**CITY OF ALBUQUERQUE
PLANNING DEPARTMENT
March 7, 2012
DRB Comments**

PROJECT # 1009162

RE: Lots 22 & 23, Block 11, Valley View Addition

**RE: REQUEST FOR APPROVAL OF MINOR SUBDIVISION (REPLAT) TO
CONSOLIDATE LOTS 22 & 23, BLOCK 11, VALLEY VIEW, INTO ONE NEW
LOT.**

Plat of  
Lot 23-A, Block 11

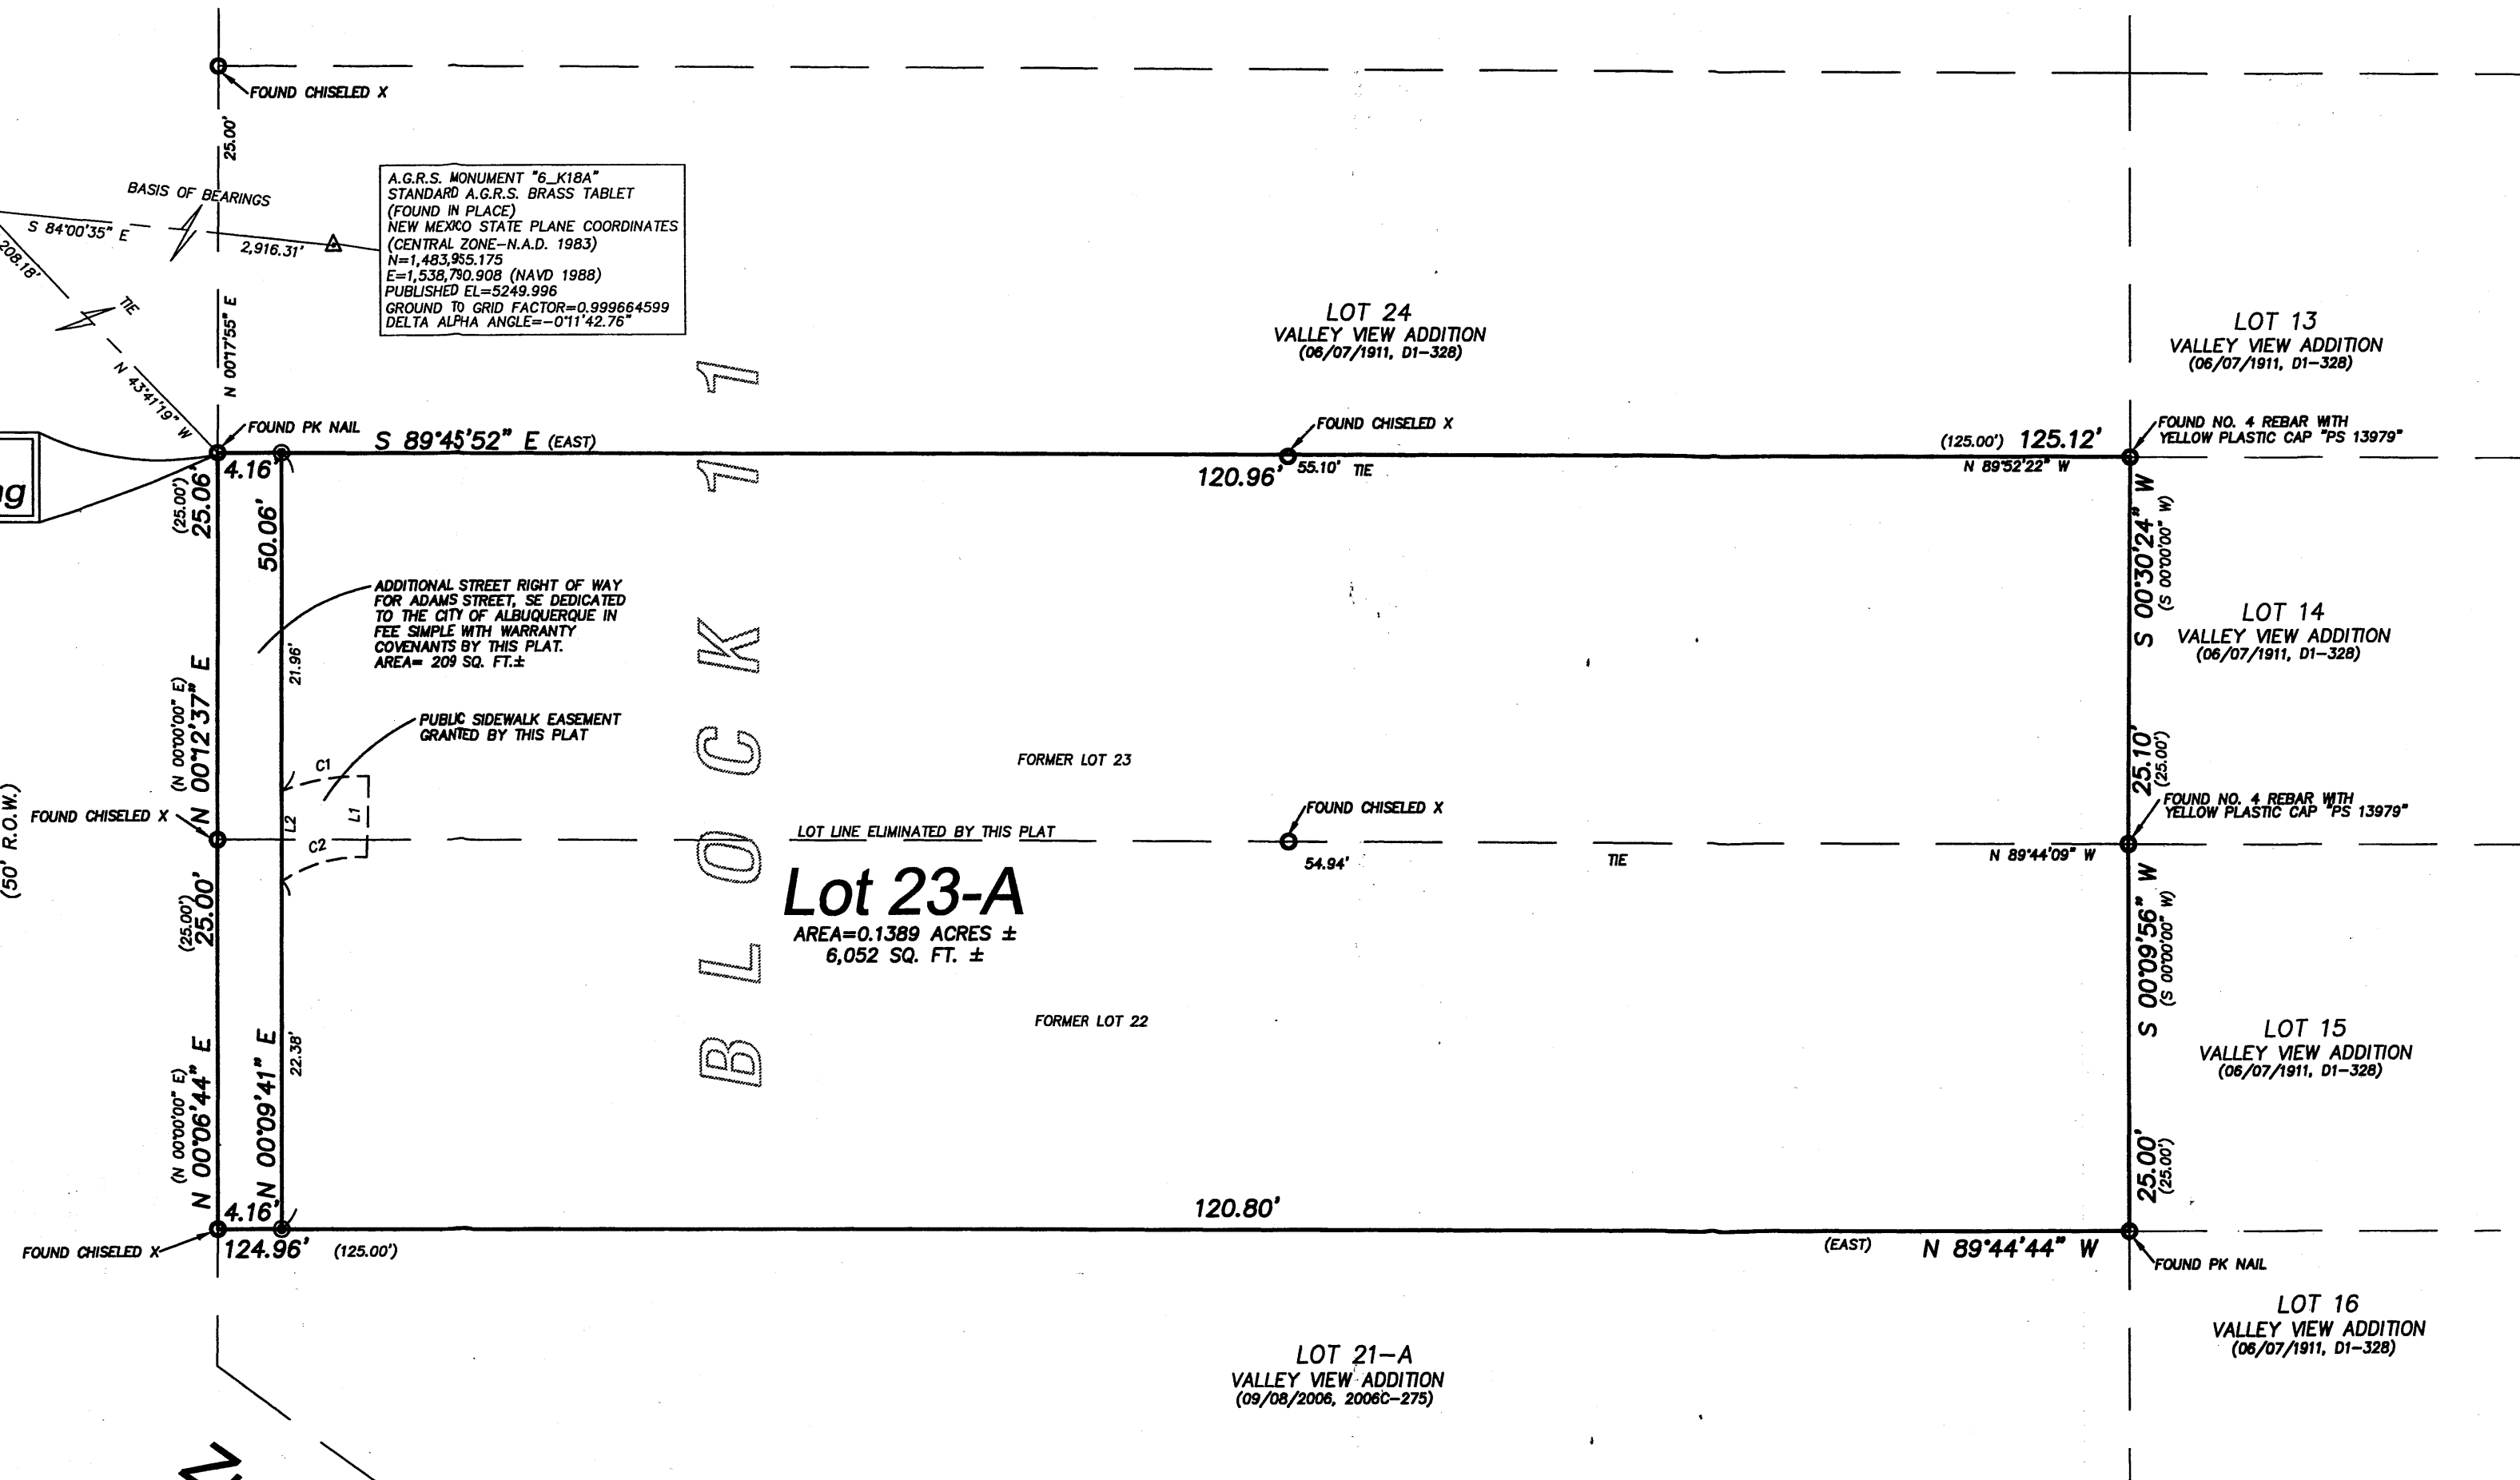
An Access and Drainage Easement is needed to benefit adjoining lots. A registered architect or engineer needs to certify that the common wall on the north property lines complies with the City's building code.
